**OXFORDSHIRE COUNTY COUNCIL'S RESPONSE TO CONSULTATION ON THE
FOLLOWING DEVELOPMENT PROPOSAL**

Application no: 14/01841/REM

Proposal Reserved matter to outline application 05/01337/OUT – Proposed commercial units for B1 use adjacent to the Oxford Road, including 65 associated parking spaces:

Location: Proposed land for Commercial units West of College House Farm, Longford Park Road, Bodicote

Title
**Sketch Scheme:
 Site Layout**

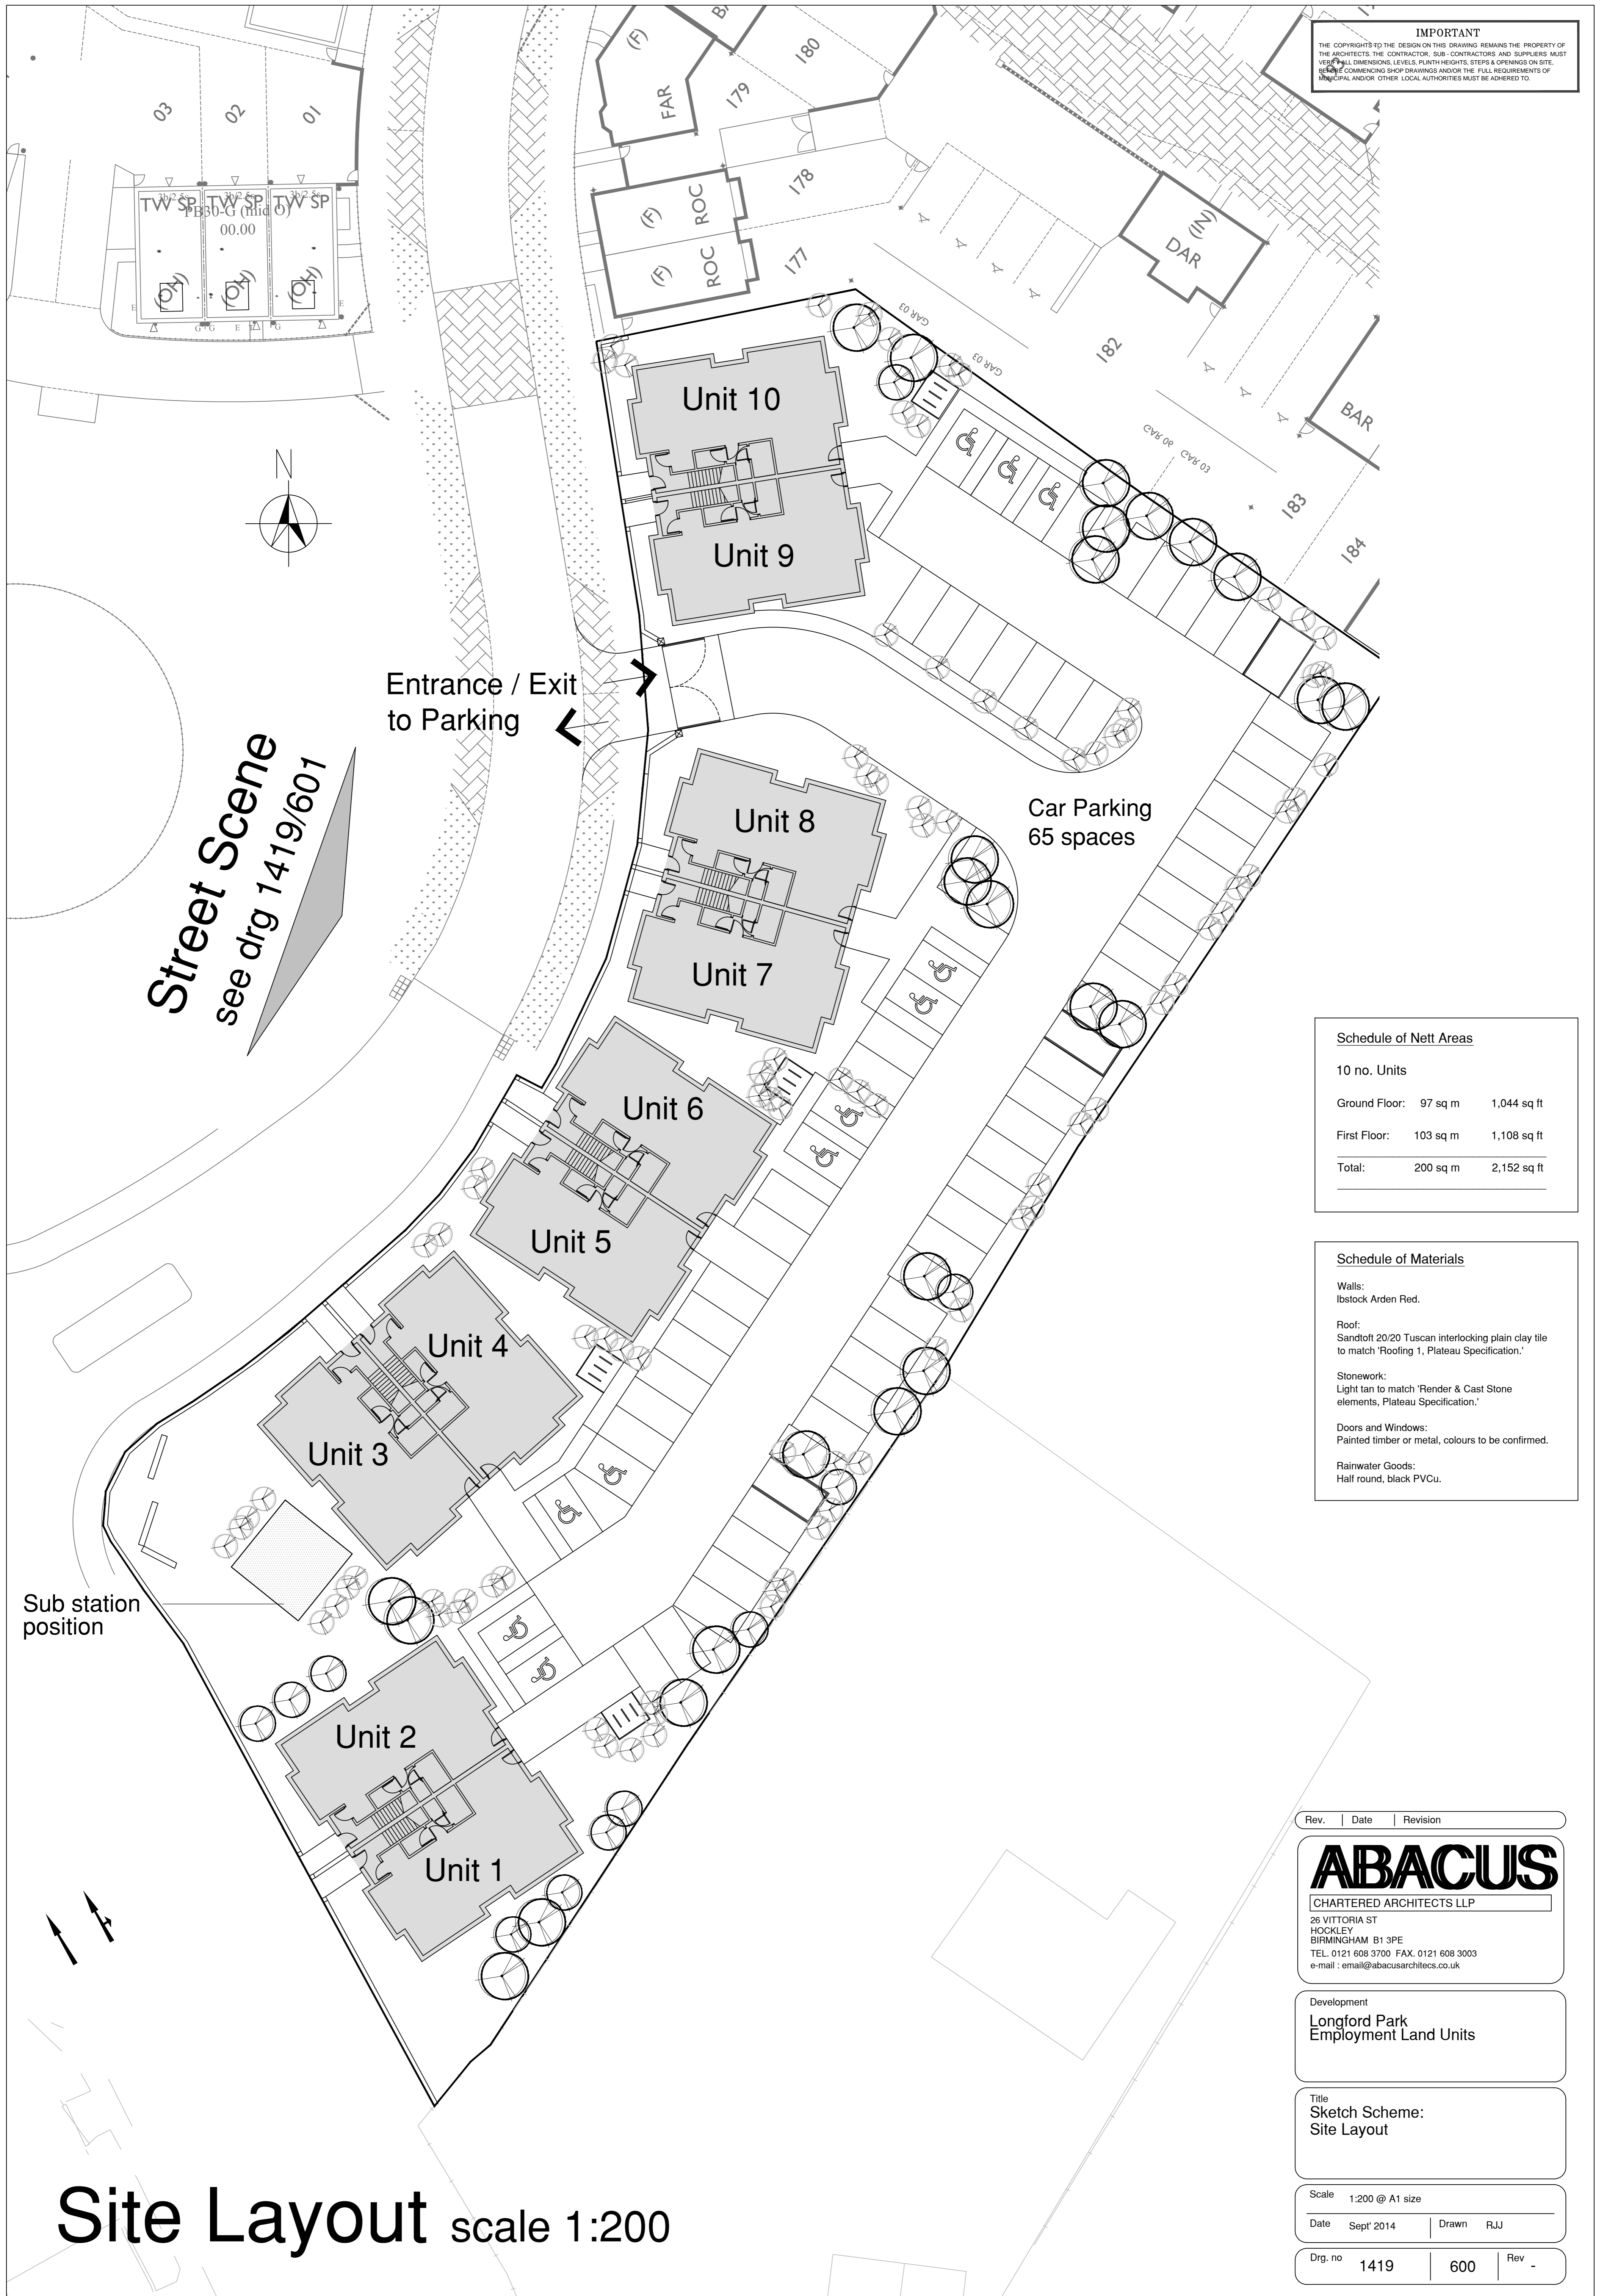
- Cycle parking provision does not meet requirements, seven cycle spaces are required for each commercial unit, this equates to four "Sheffield" type cycle stands
- No details have been submitted in terms of refuse collection
- No details have been submitted in terms of servicing arrangements (loading/unloading spaces)
- Unable to scale the dimensions of the parking space as no scale bar has been placed upon the plan
- One parking space appears to be obstructing another, located in the north-east corner of the site
- No vehicle tracking has been submitted in terms of a large car, refuse vehicle, servicing lorry etc.
- The disabled parking spaces located within the vicinity of Unit 2, would require multiple reverse manoeuvres to egress these spaces it is recommended these be relocated
